Application No: AB/76/21/L
Site Address: 54 Tarrant Street Arundel BN18 9DN
Description of works: Listed building application for alterations to fenestration and installation of 4 x new rooflights and waterproofing system to basement and outbuilding.

Thank you for your internet representation made on 6th July 2021 which has been recorded as an objection with the comments as follows:

Objection

PROPOSED DETAIL FOR
WINDOWS W6, W7, W8 + W9
WHICH WILL BE DOUBLE GLAZED

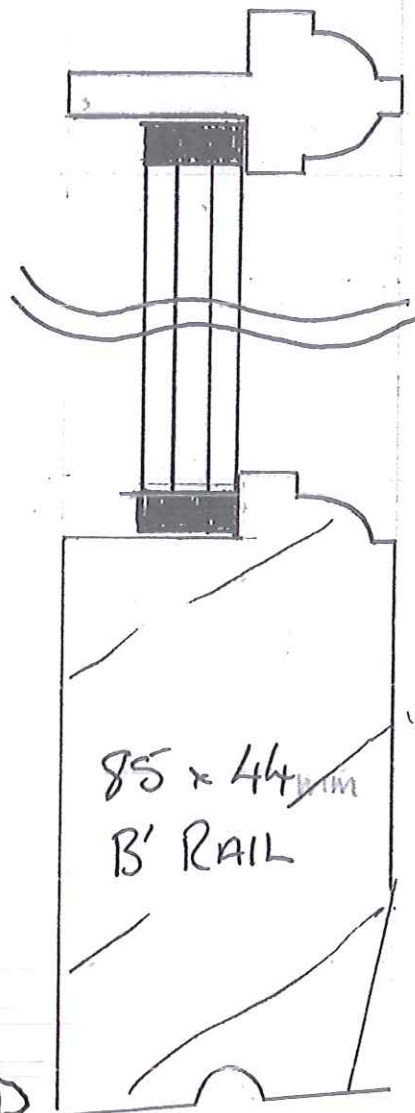
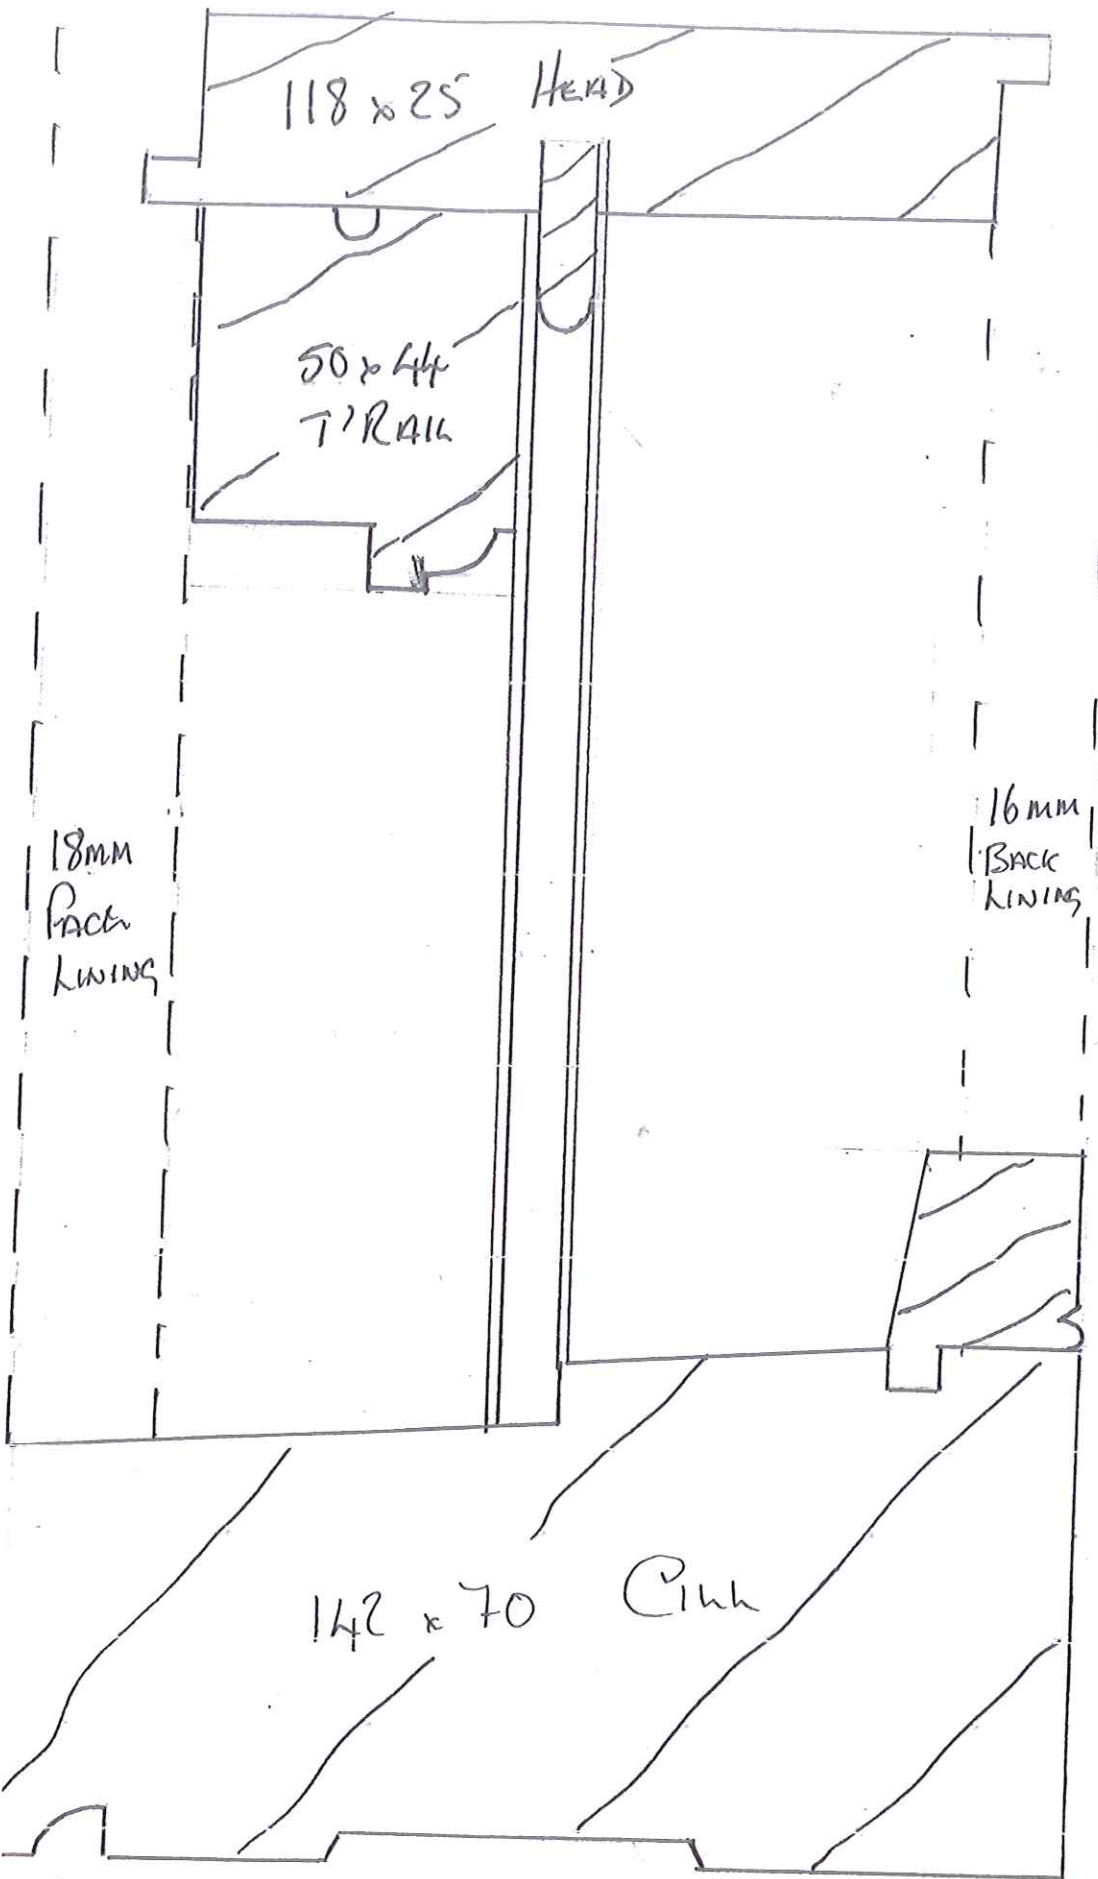
The Panel are concerned at the reference in the Design and Access Statement to double glazing for high level windows on the rear elevation of the building. There is a detailed section of the proposed new double glazed windows which shows the use of slimline units with glazing bars 2mm thicker than the existing ones. Given the location of the windows on the rear elevation the Panel consider that in this respect there will be no adverse impact on the appearance of the conservation area.

However, there is no detailed condition report to indicate the age of these windows or that they are beyond reasonable repair. Historic England's advice is quite clear that repair is the preferred option before total replacement since the latter can involve the loss of significant historic fabric. This issue is also relevant in respect of the other windows proposed to be replaced.

REPLACEMENT, ALTERED + NEW WINDOWS
54 TARRANT STREET, ARUNDEL

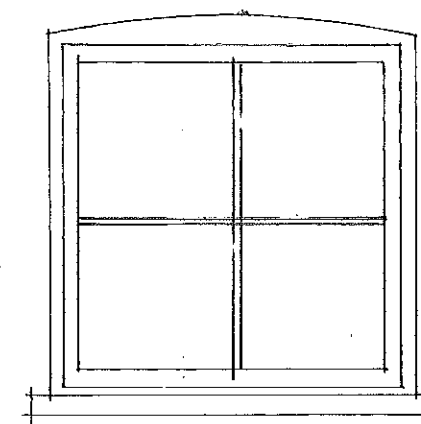
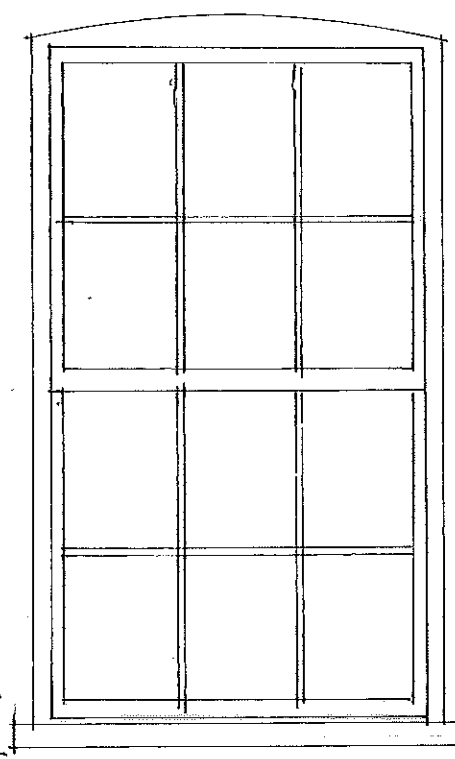
In the absence of information to support the loss of the existing windows then the Panel consider that the grant of LBC would set a precedent for similar inappropriate proposals in the conservation area and possibly in historic buildings and areas elsewhere in the District. It is considered that on this issue the proposals will conflict with the relevant paragraphs of the NPPF and policies contained in the ADLP relating to the protection of designated heritage assets.
